OFFICIAL NOTICE OF DECISION

CITY OF ALBUQUERQUE
PLANNING DEPARTMENT
DEVELOPMENT REVIEW BOARD
2012

Project# 1008830

12DRB-70119 MAJOR – SITE DEVELOPMENT PLAN FOR BUILDING PERMIT

SP-1

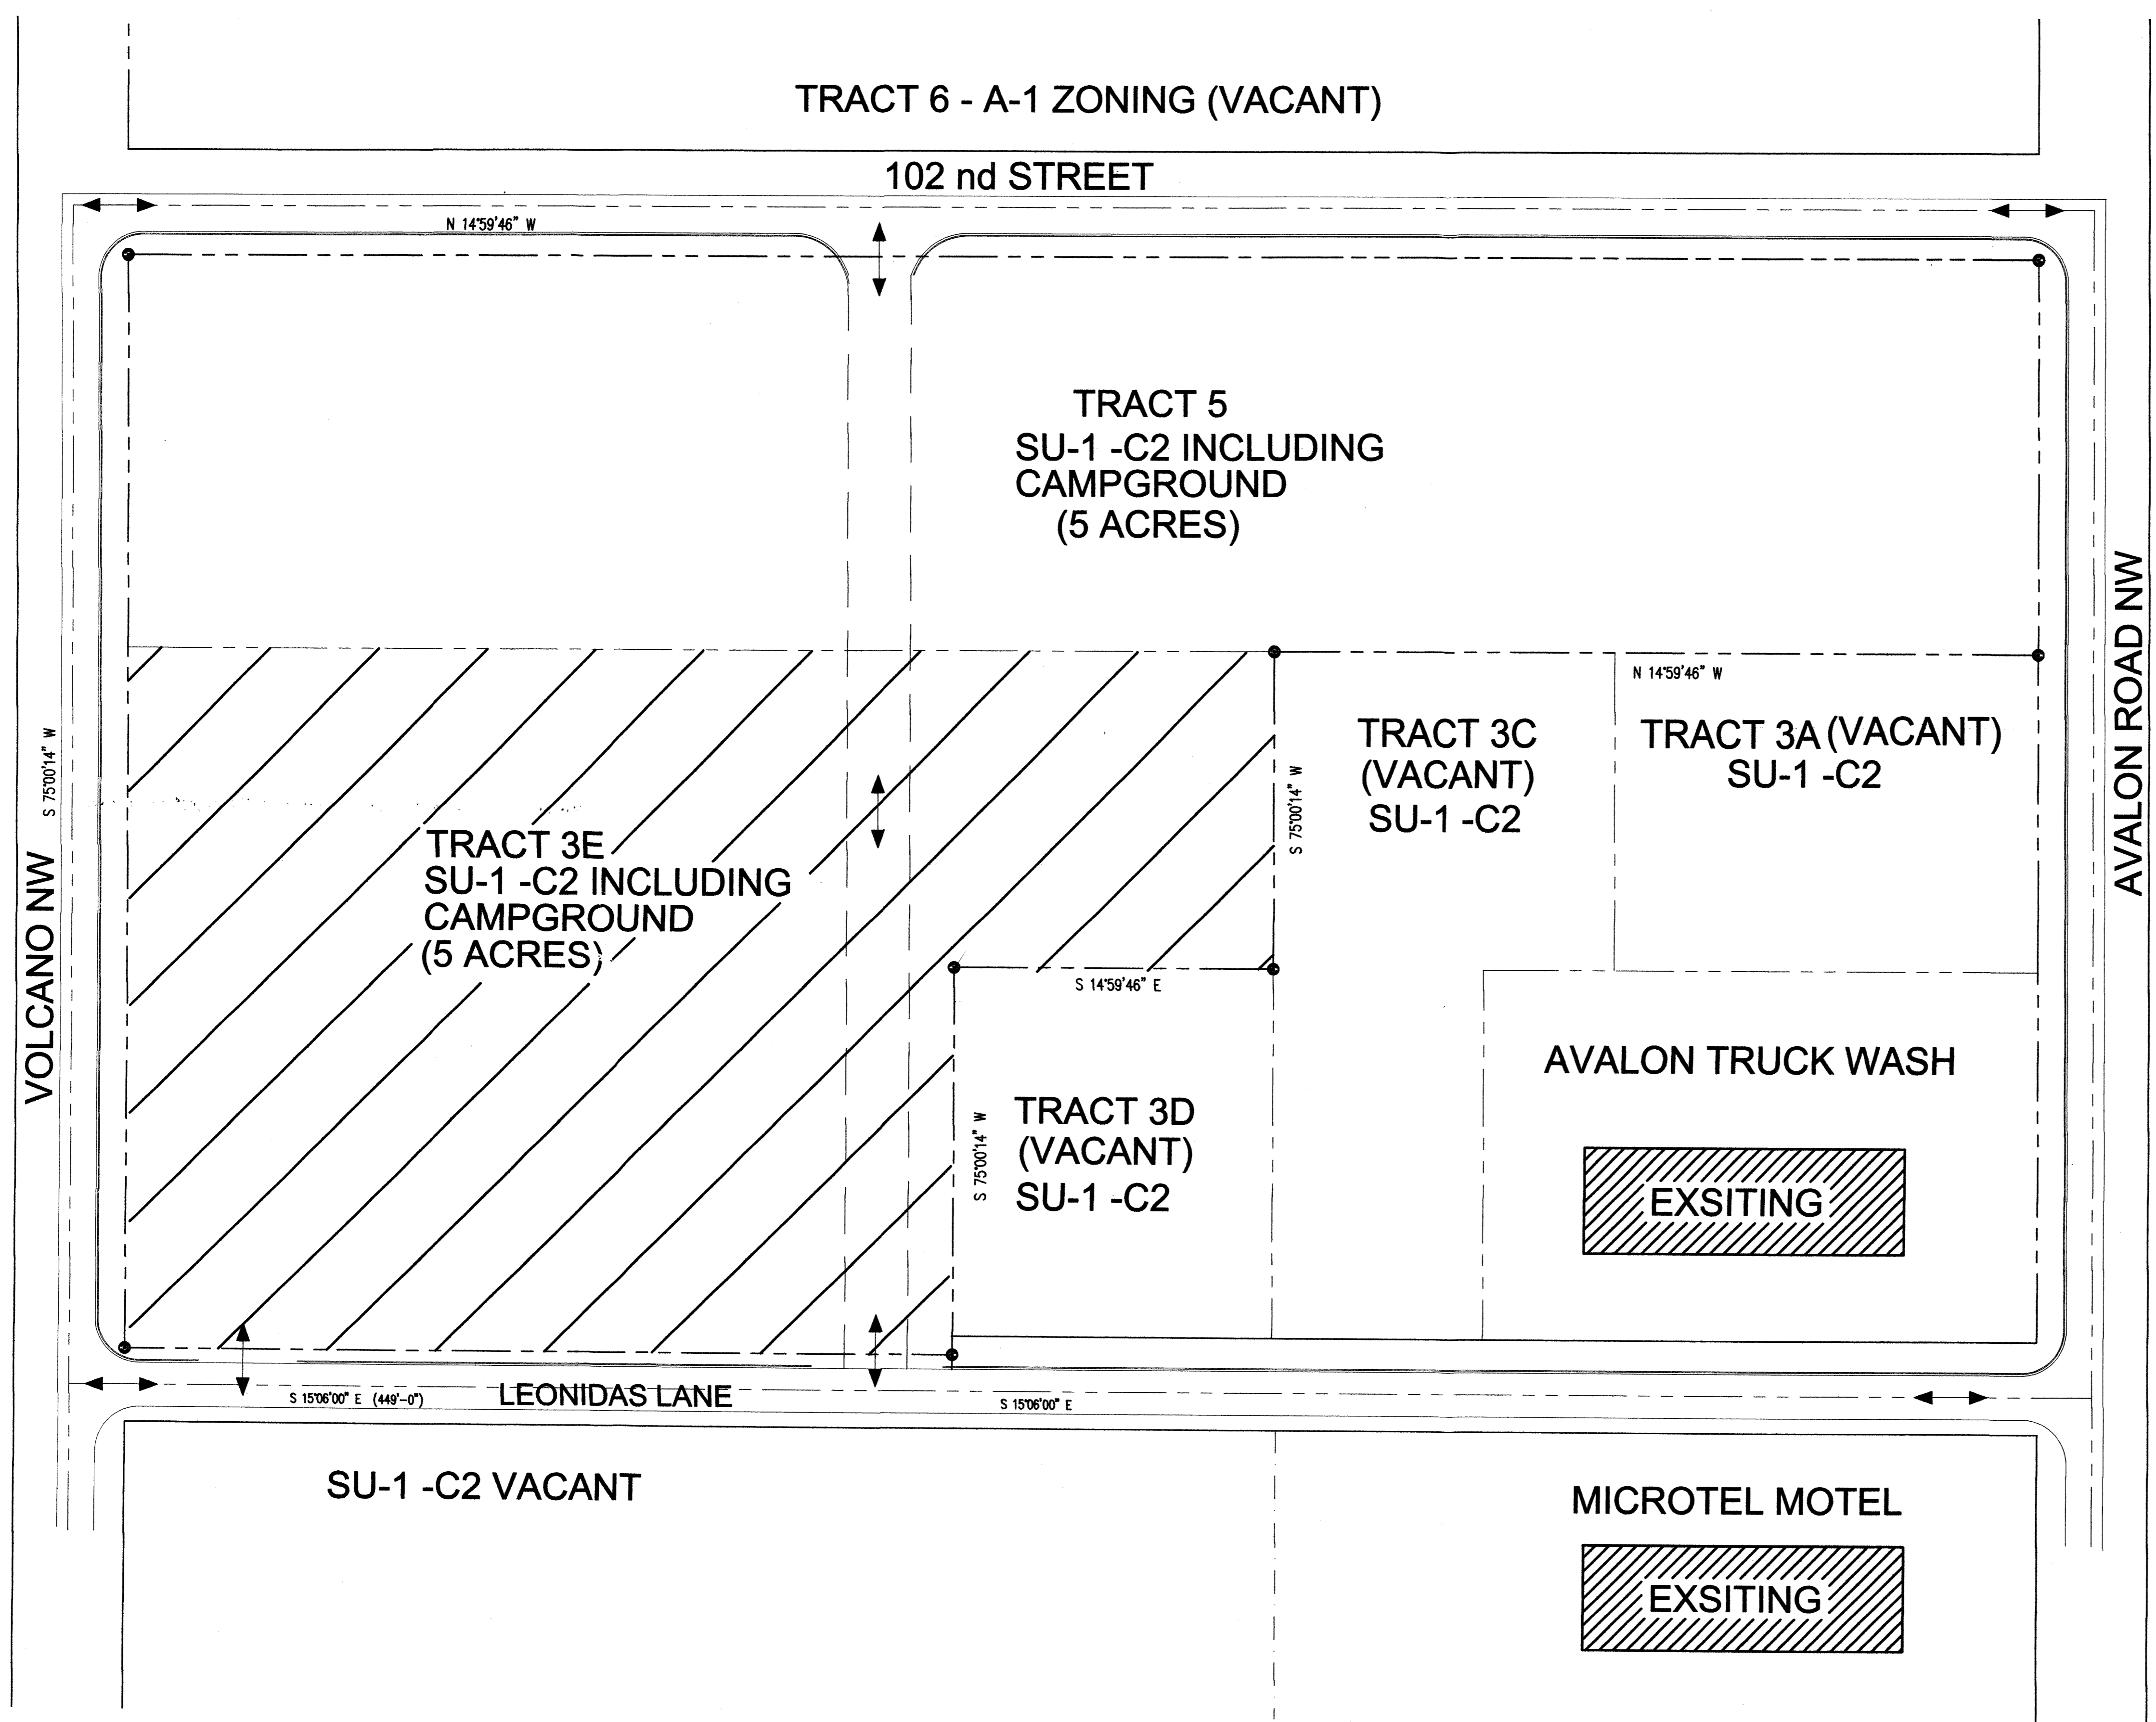
Leonidas Lane is noted as public right of way on the site plan; however, as-built information provided by the applicant indicates that this is a private access easement. Please revise the notation and provide the recording information.

A 34-foot wide roadway access easement is shown on the site plan; this easement must be a private access easement. Provide the recording information for the easement.

Define the width of all proposed entrances.

Show the 6-foot wide, ADA accessible, pathway from the ADA parking stalls to the building.

Please clarify the limits of all paving.

Per our discussion, the parking areas were to be gravel. The drainage calculations in the approved drainage report are for gravel, yet the site plan has a note for asphalt.

Please show where the site will be paved and where it will be gravel.

SP-2
04.12.2012

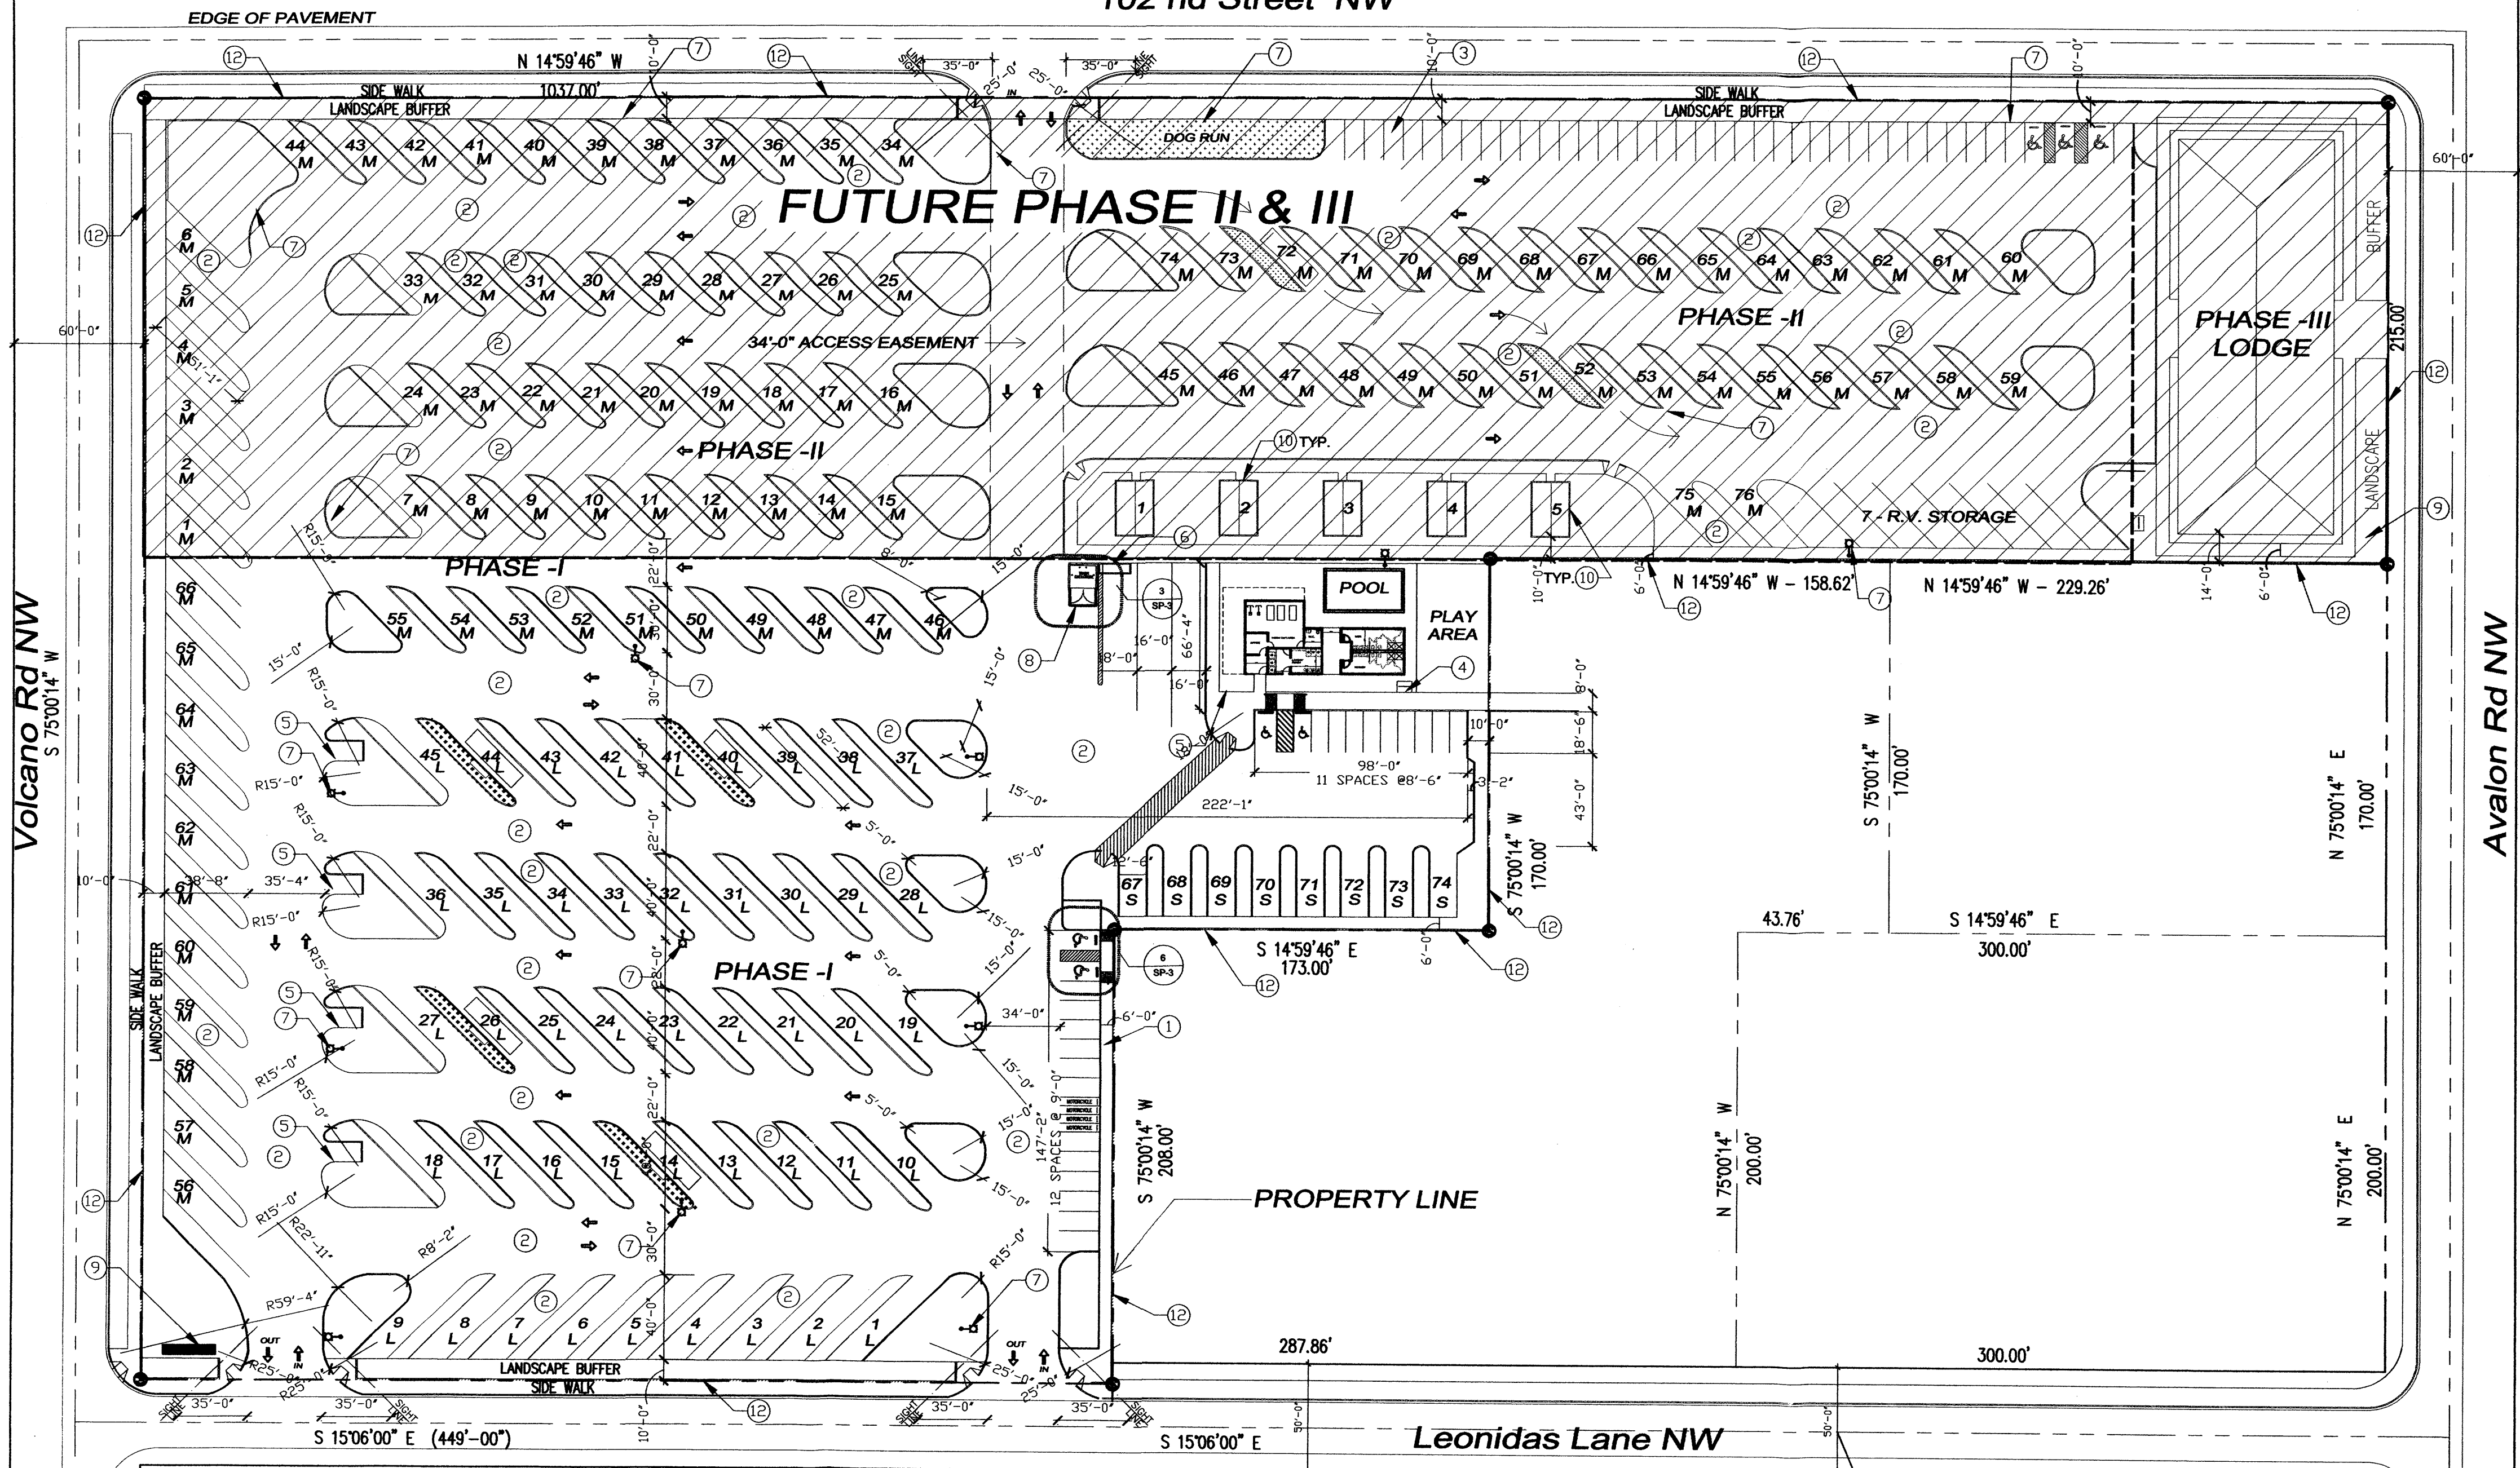
- Please show all access points along Avalon Road, Leonidas Lane, Volcano Road, and 102nd Street on Sheet SP-2. Revise the property lines to match what is shown on the SPBP.
